M60/M62/M66 Simister Island Interchange

7.11 Statement of Common Ground with Environment Agency

**M60/M62/M66 Simister Island Interchange
Development Consent Order 202[]**

Version	Date	Status of Version
P01	24/09/2024	Examination Deadline 1

FIGURE 13.2

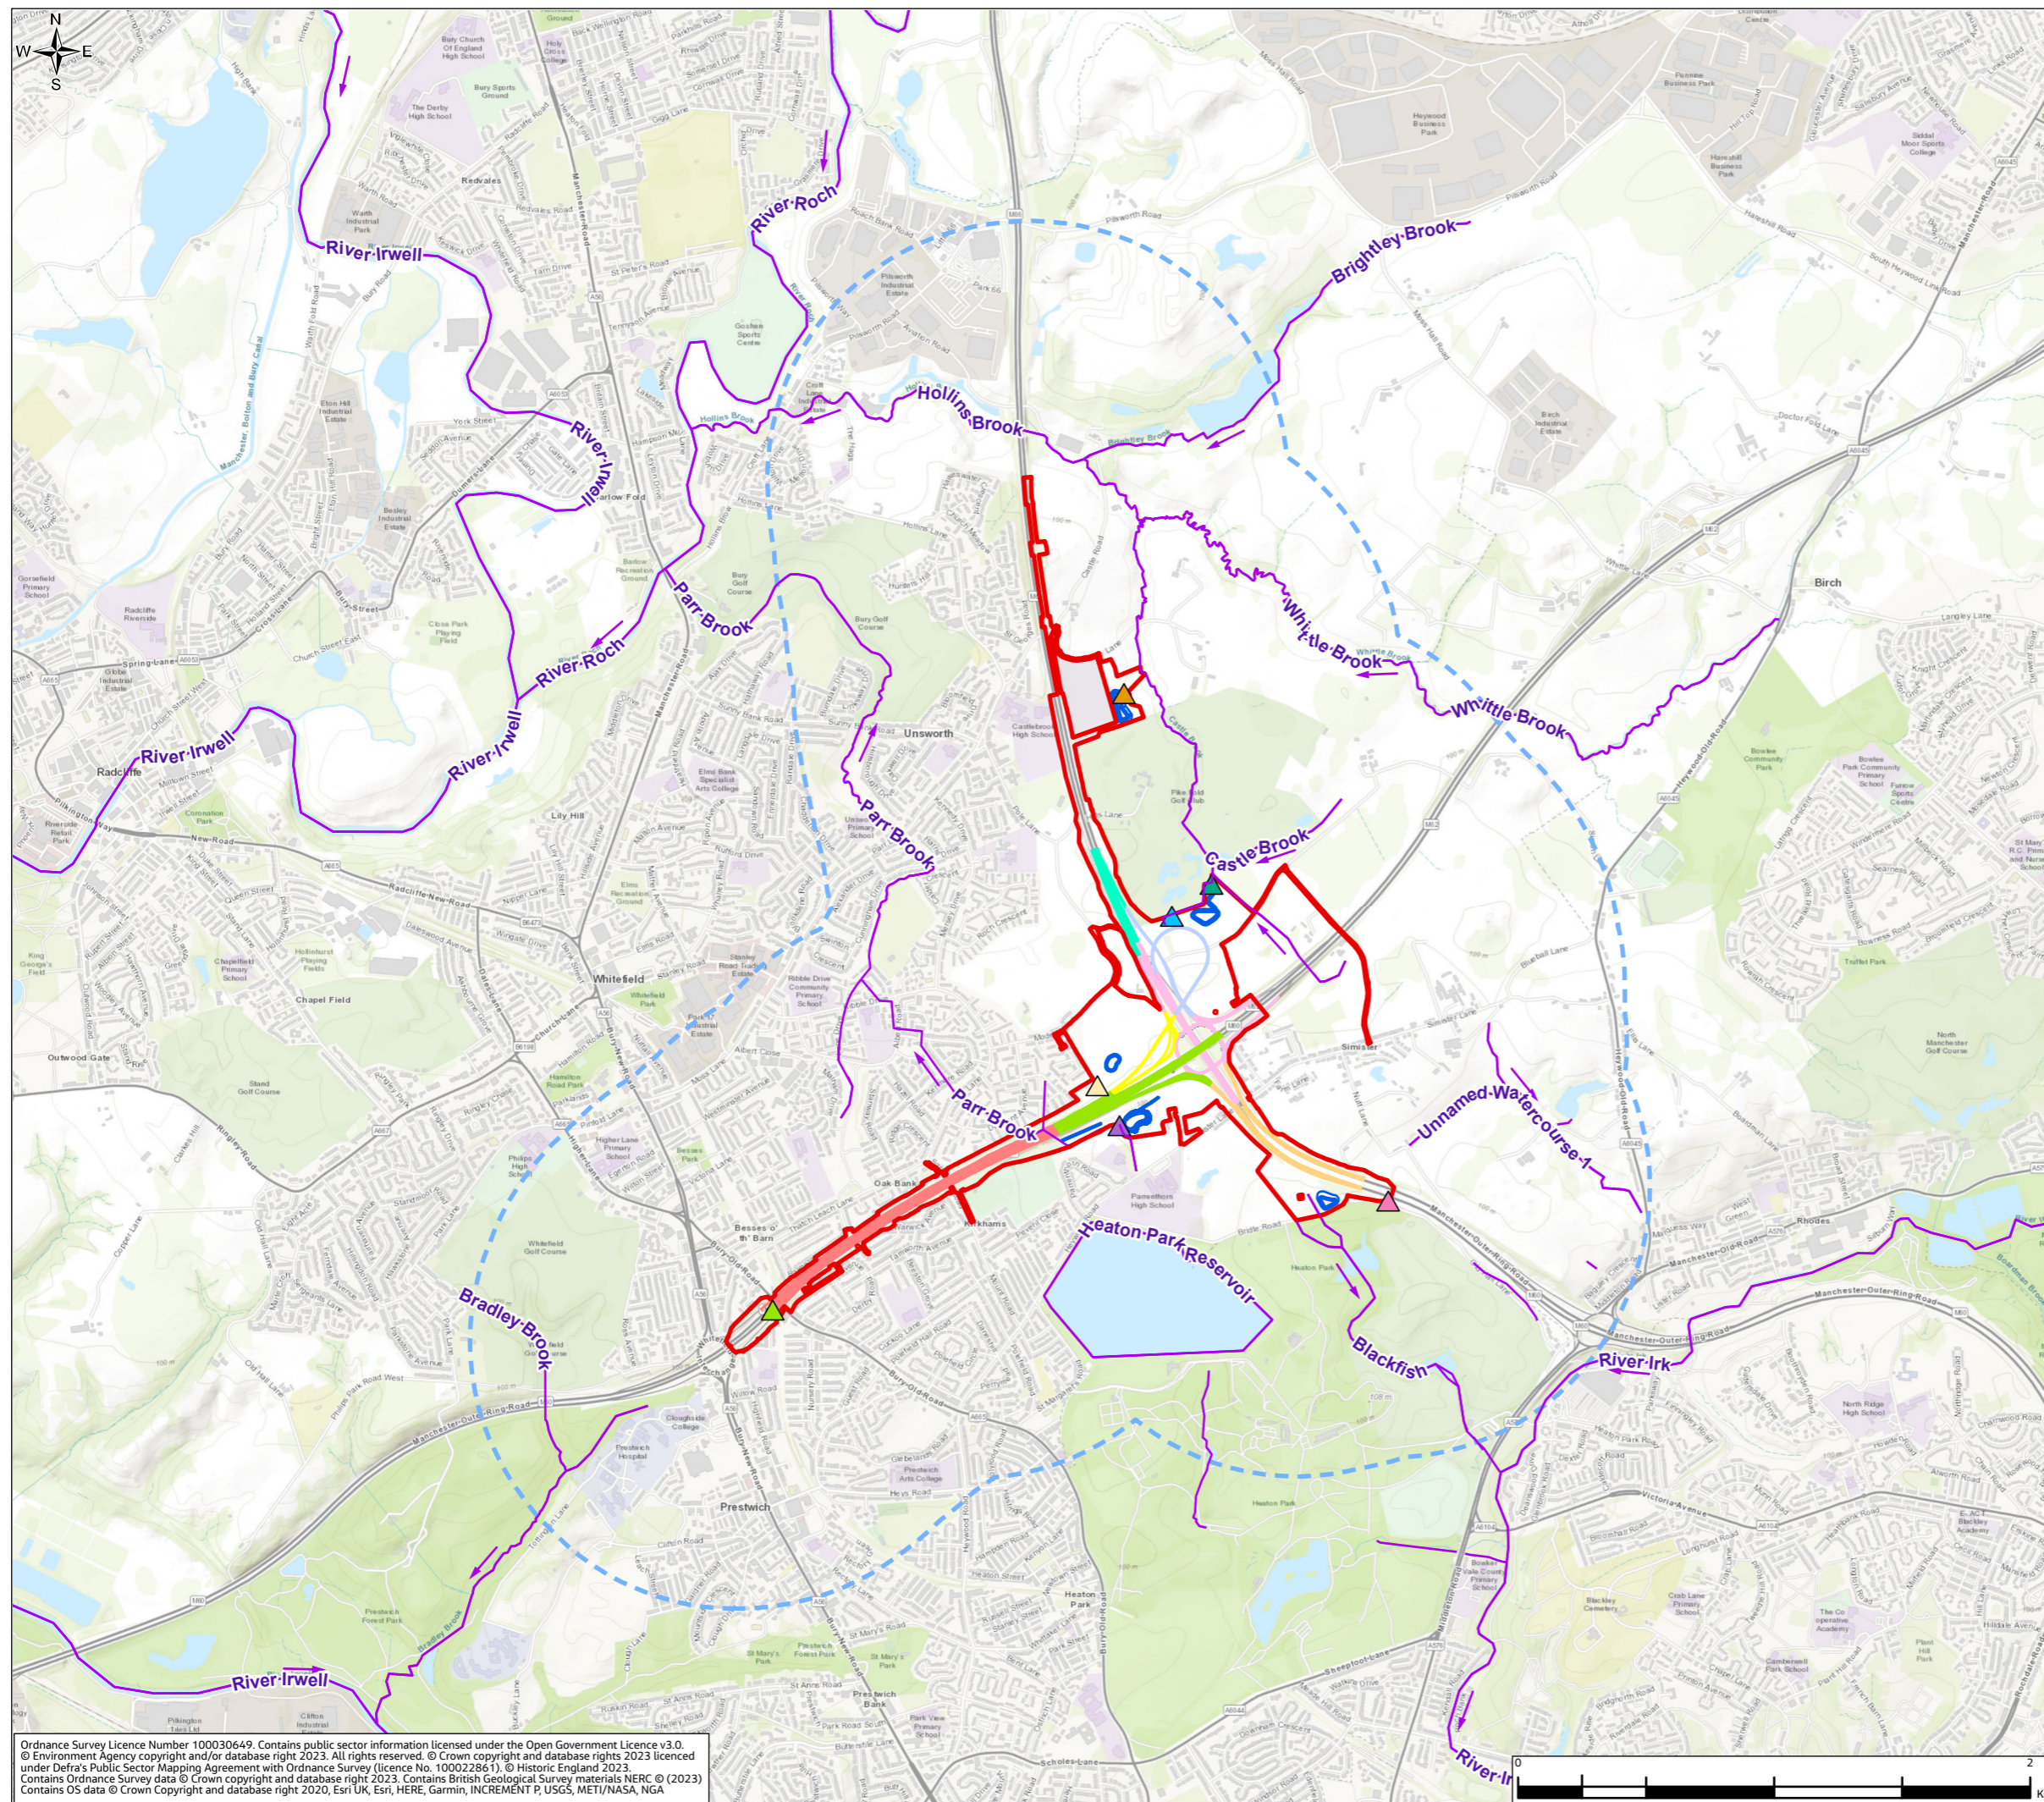
Ref	Issue	Doc Ref	Environment Agency's Position	The Applicant's Position	Agreement Likely	Status	Date
		Environment [APP-073]	<p>Statement Appendices [APP-116] and notes the amendments that have been made and confirms that we have no further comment.</p> <p>Figure 13.2: Proposed Outfall Locations of the Environmental Statement Figures - Chapter 13 Road Drainage and the Water Environment [APP-073] has been reviewed by the Environment Agency and we agree the amended figure provides a clearer visualisation of the outfall locations. The Environment Agency has confirmed no further comment in relation to this matter.</p>				
8	Impact of dewatering on baseflows of watercourses, and associated WFD quality effects	<p>Appendix 13.1: WFD Compliance Assessment of the Environmental Statement Appendices [APP-116]</p> <p>First Iteration EMP [APP-127]</p> <p>Appendix H: Outline Surface and Ground Water Management</p>	<p>The Environment Agency's assessment of an early draft WFD Compliance Assessment requested additional details on the impacts of dewatering on baseflows and associated WFD quality effects on Parr Brook and Castle Brook.</p> <p>The Applicant has confirmed that Parr Brook would not be impacted by any dewatering activities. The Environment Agency notes further details of impacts without mitigation, and details of the essential mitigation to reduce the impacts of change to baseflows has been provided within Appendix 13.1: WFD Compliance Assessment of the Environmental Statement Appendices [APP-116]. The Environment Agency confirms that changes have been made</p>	<p>The Scheme mitigation to ensure any impacts of dewatering are negligible at a waterbody scale is secured through commitment W25 in the Register of Environmental Actions and Commitments within the First Iteration Environmental Management Plan [APP-127], and specific dewatering measures set out in Appendix H: Outline Surface and Ground Water Management Plan [APP-135] of the First Iteration Environmental Management Plan [APP-127]</p> <p>Commitment W25 and the Outline Surface and Ground Water Management Plan will be contained in the Second Iteration Environmental Management Plan and implemented through Requirement 4 of the draft Development Consent Order</p>	Yes	Agreed	13/05/24 and 09/09/24
